From: Contact Centre (CRM) <contact@ribblevalley.gov.uk>
Sent: 08 March 2024 09:22
To: Planning
Subject: Planning Application Comments - Application 3/2023/1011 FS-Case-593669613

Planning Application Reference No.: Application 3/2023/1011

Address of Development: 41-43 Wellgate

Title: Proposed Refuse Plan	Drawn: HA
Client: Wajid Mahmood	Checked:
Date: 1-12-2023	Paper: A3
Drawing No: HAD3858-10	Scale: 1:200
Revision:

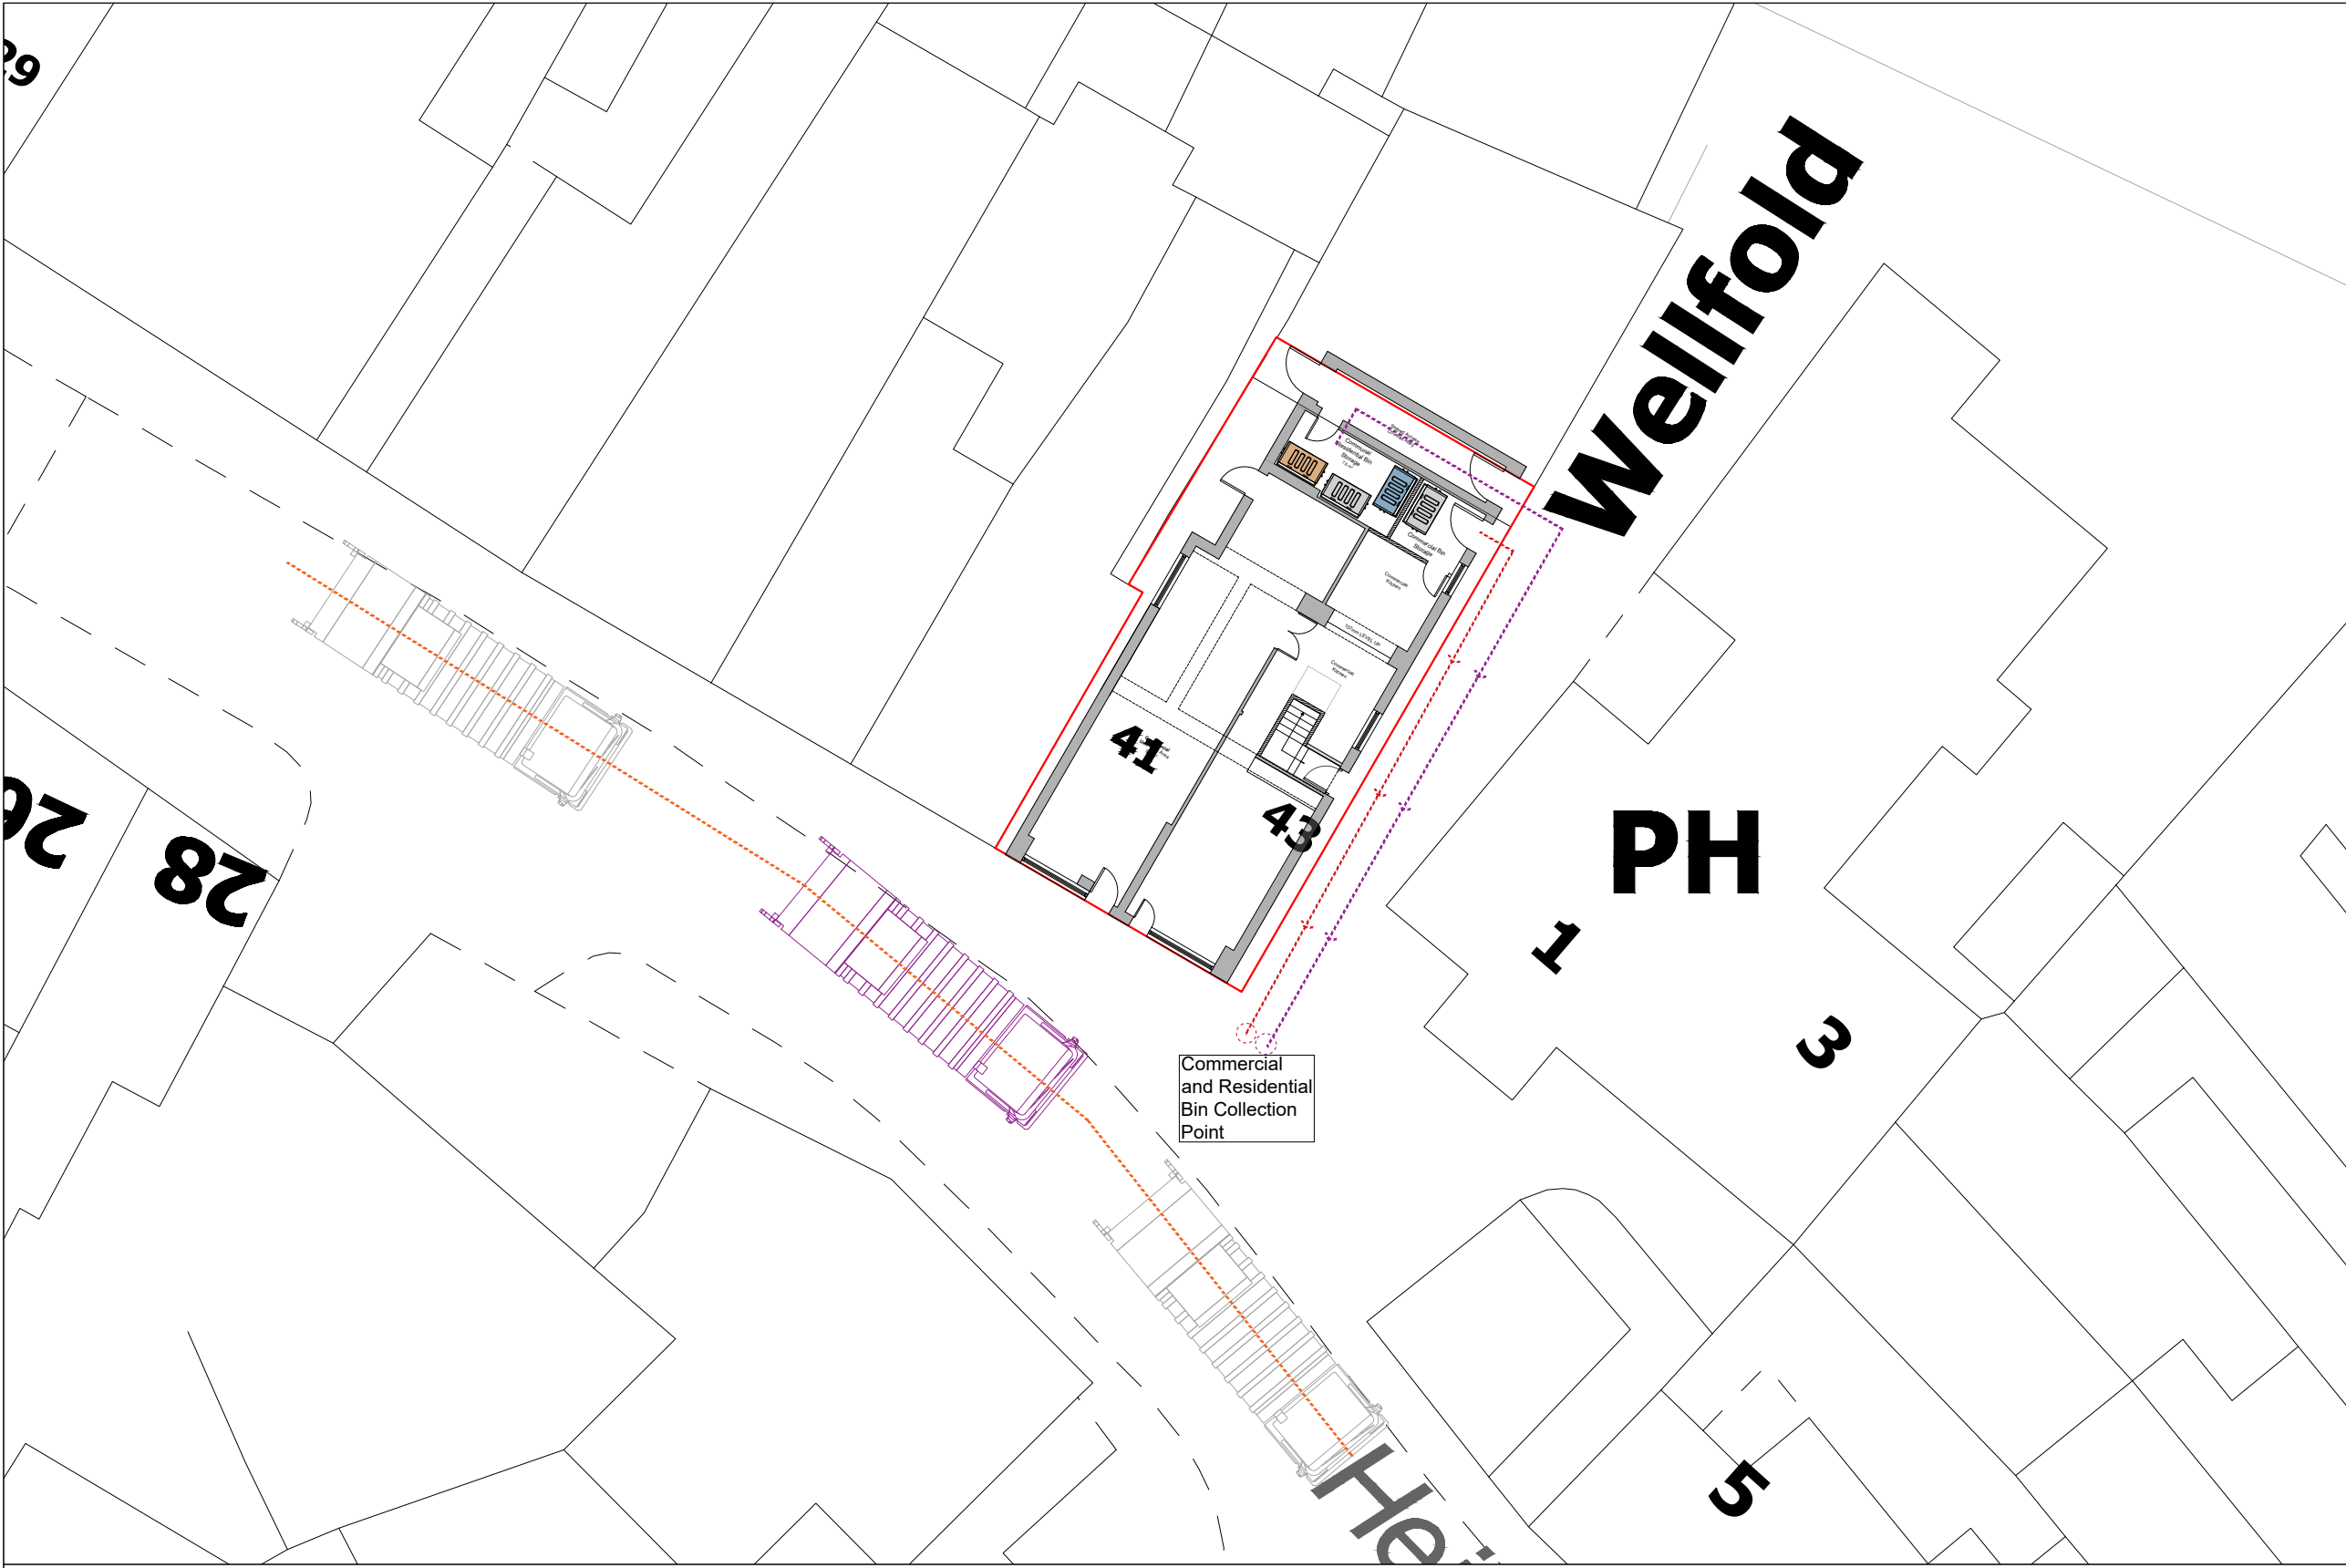
The takeaway at No 35 already uses Wellfold regularly as the inappropriate location for commercial bins, causing obstruction to vehicles accessing the lane. The waste collection plan does not seem to adequately allow for the either the existing or proposed increase in bin storage and access for collection. Whilst, [REDACTED] we very much appreciate the frequency of road sweeping, there is a considerable amount of litter generated in the area.

PROPOSED SECOND FLOOR PLAN - 112m²
1:100 @ A3

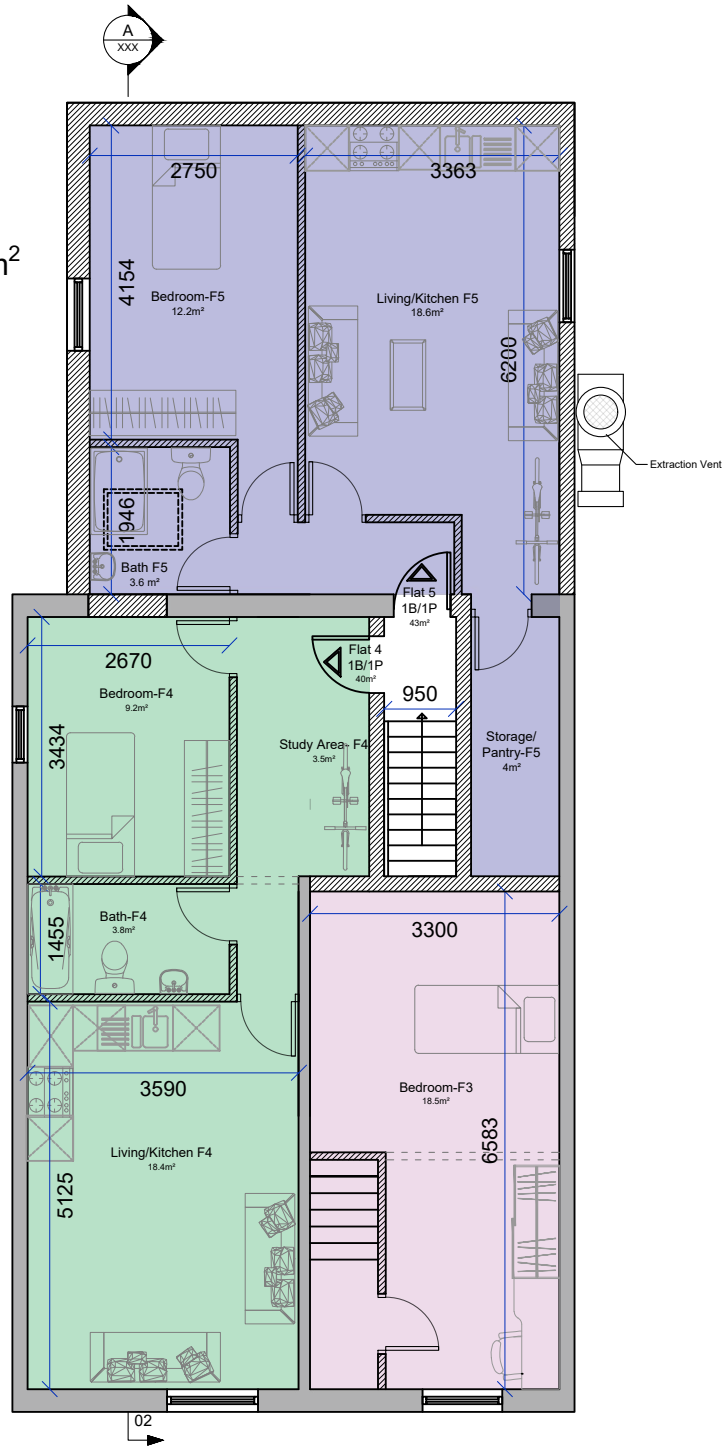
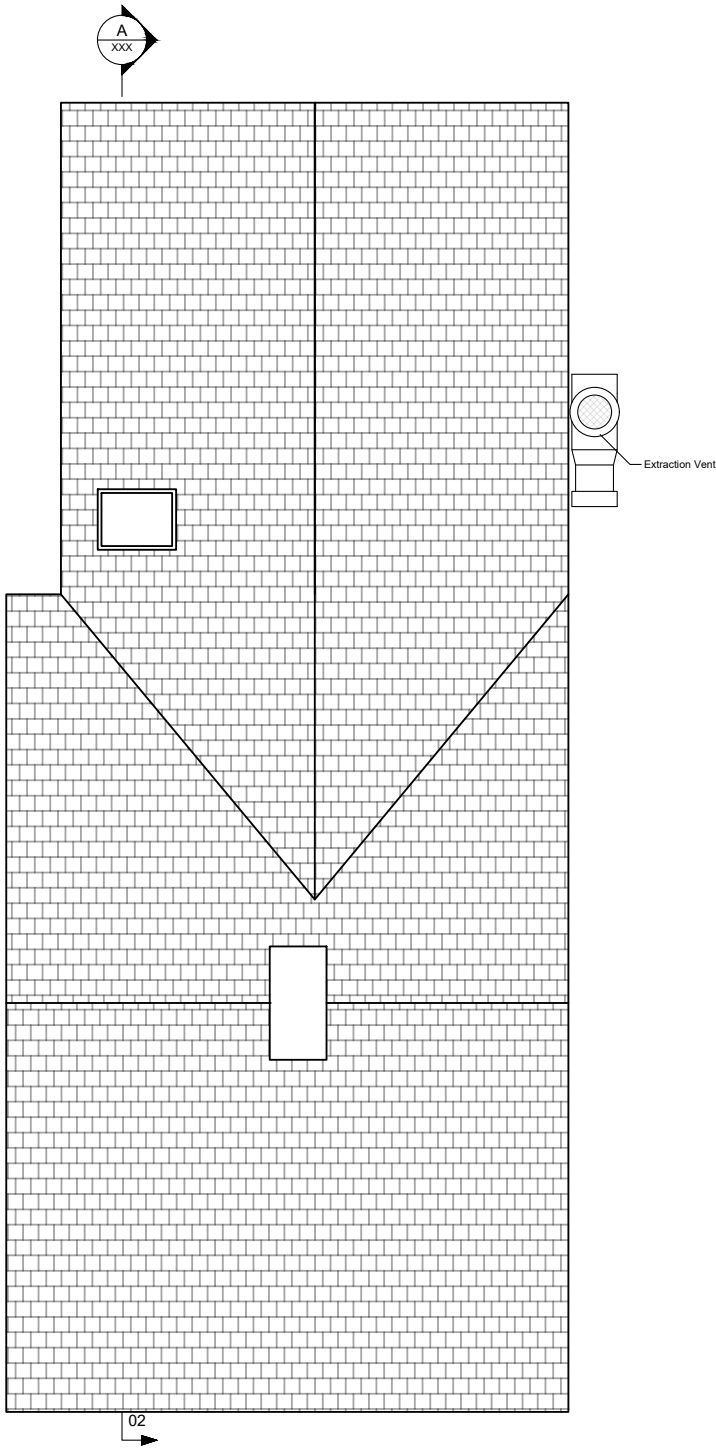
There is no detail of colours, external finishes or proposed materials in the submission. The additional rear storey extension would be very visible and intrusive, and reduce the open views to Pendle [REDACTED] in the conservation area we are subject to very strict rules regarding these issues. Submission of this planning application is an opportunity to improve the conservation area by ensuring that any development conforms with the conservation area town plan. Please find below some of the relevant sections taken from Ribble Valley Council's document regarding the approach to protecting the conservation area:-
